PLANNING BOARD REPORT PORTLAND, MAINE

Jewish Community Center and Preschool/Daycare 1342 Congress Street

Conditional Use & Level III Site Plan Review

Project # 2015-058

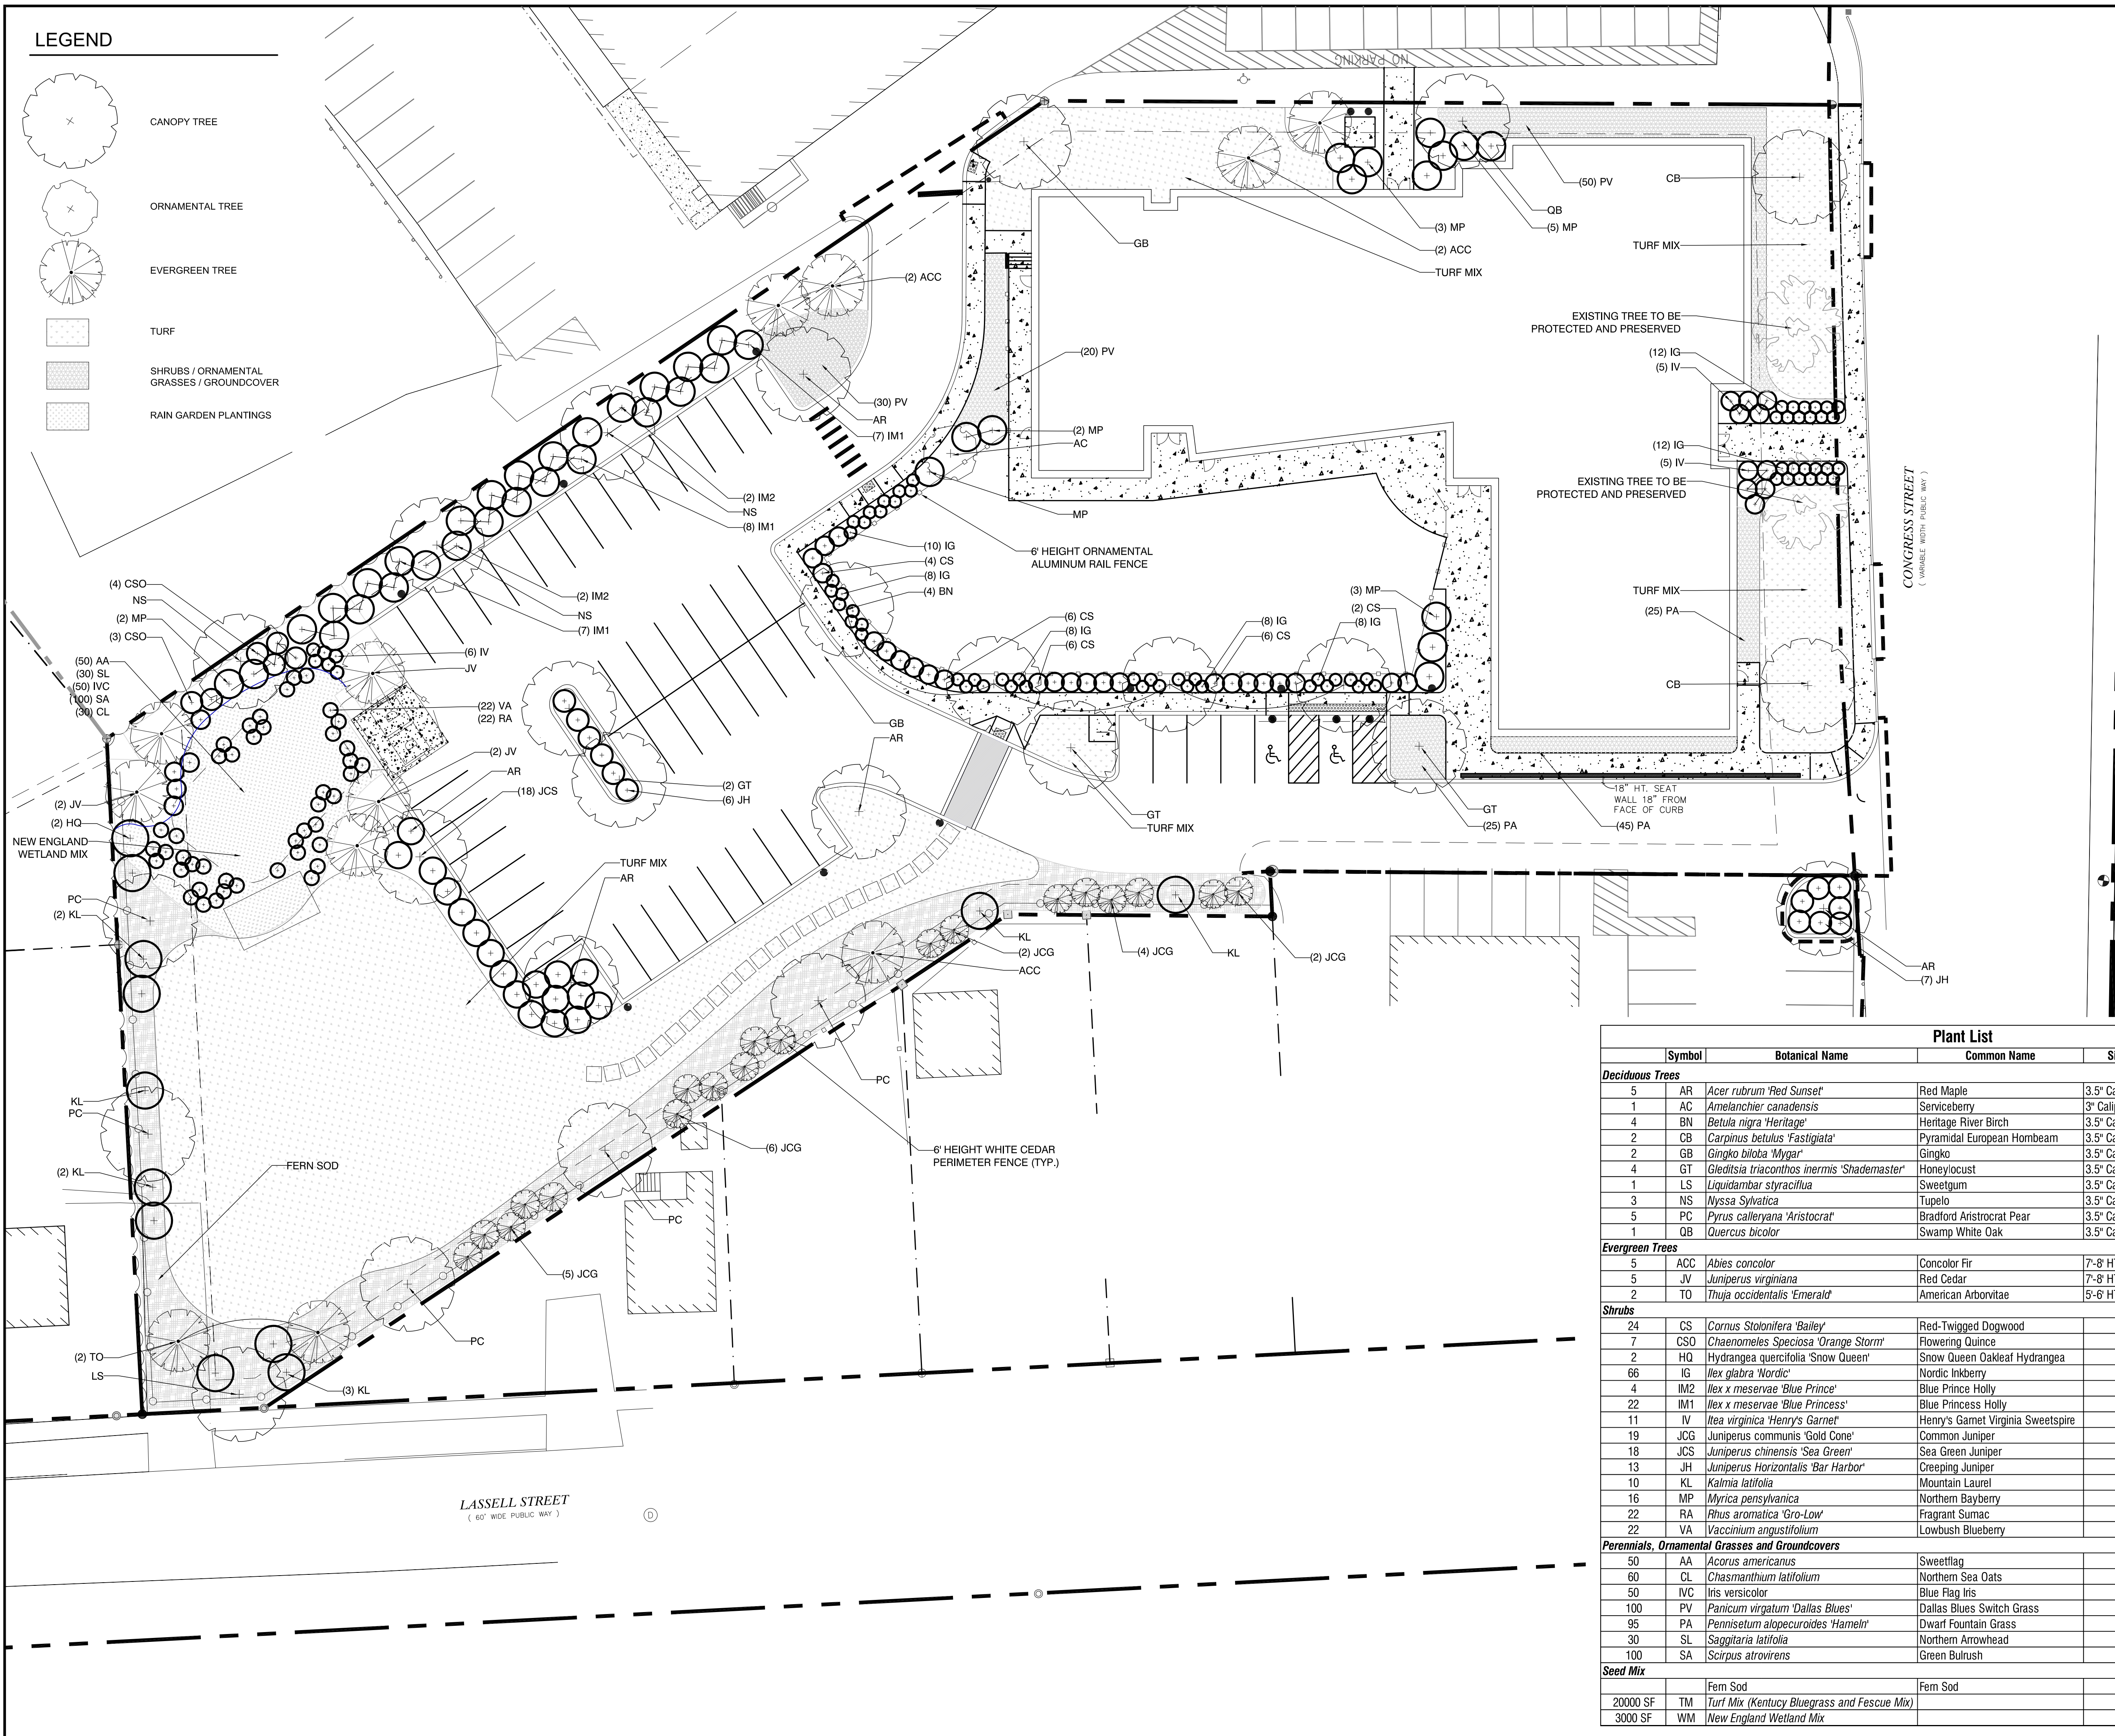
The Landscape Plan (Plan P16) was revised to include additional planting and a 17 foot wide landscaped island between the parking in the dental offices site and the widened drive into the neighborhood center.

At the time of completing this report the City Arborist has not provided final comments and these will be circulated to the Board at the hearing. The creation of the new island is welcomed.

D1 SOUTHWEST ELEVATION
SCALE: 1/8" = 1'-0"

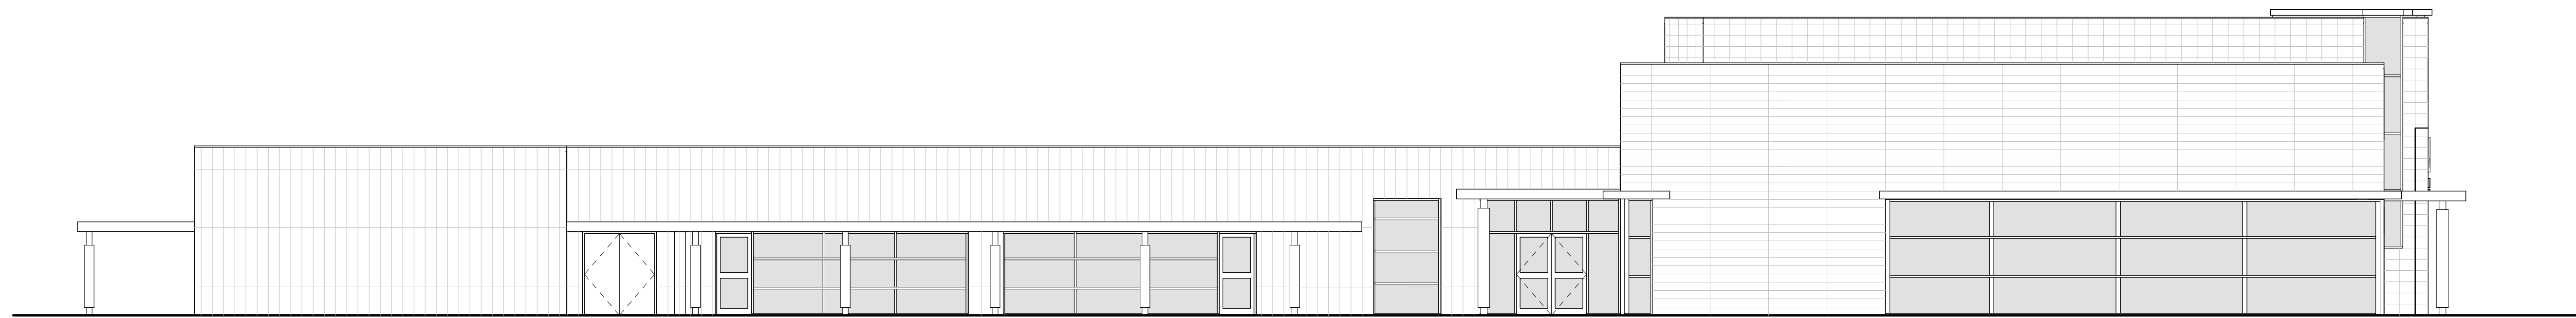
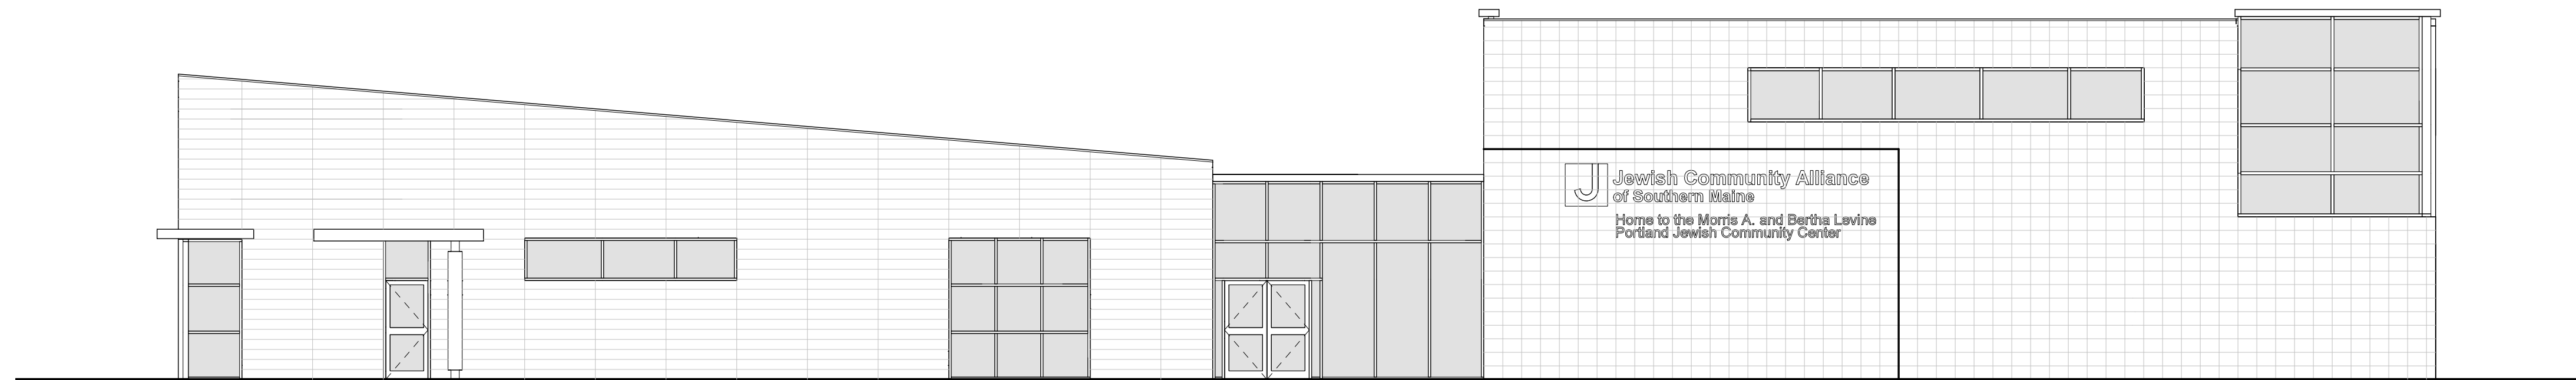
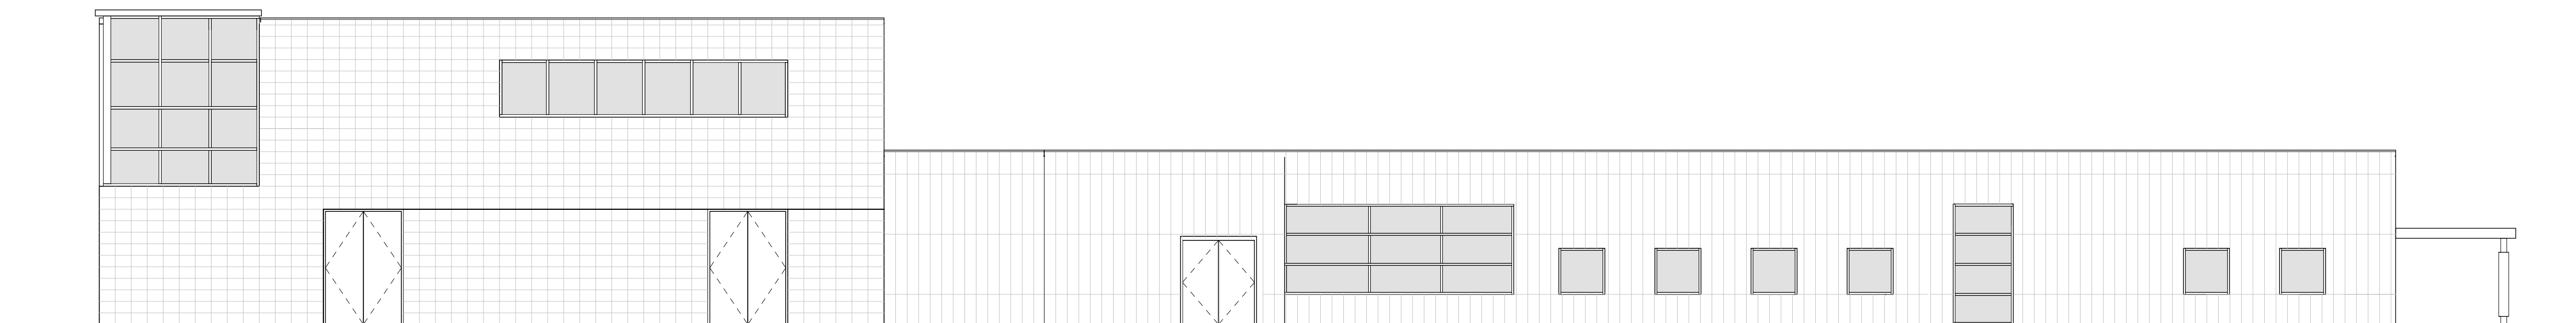
The letter from the Libbytown Neighborhood Association (PC 5) raises concerns regarding the design of the new building as it faces Congress Street. There are no design standards that apply to this R5 location and the proposed front and east elevations are shown below:

We are very appreciative with the feedback provided us from the Libbytown Neighborhood Association in their letter to the Jewish Community Alliance of Southern Maine dated June 30, 2015. With respect to the concern raised regarding the elevation of the front façade of the community hall, and the desire for additional embellishment, we offer the following. The form of the community hall is being carefully designed to consider the appropriate scale at both a vehicular and pedestrian level on the north corner of the site while responding to internal program demands. Its architectural expression is principally achieved through its cladding and fenestration materials and layout as well as the graphic nature of the building's sign, all of which are being constantly refined through the design process. The exterior elevations submitted as part of the Planning Board submission graphically represent these qualities but don't offer the experiential perception of perspective and the relationship of this form to its context – the surrounding neighborhood and adjacent structures. We are glad to continue to update interested parties as we progress in this endeavor and are confident that this building's expression will be an enhancement to the community.
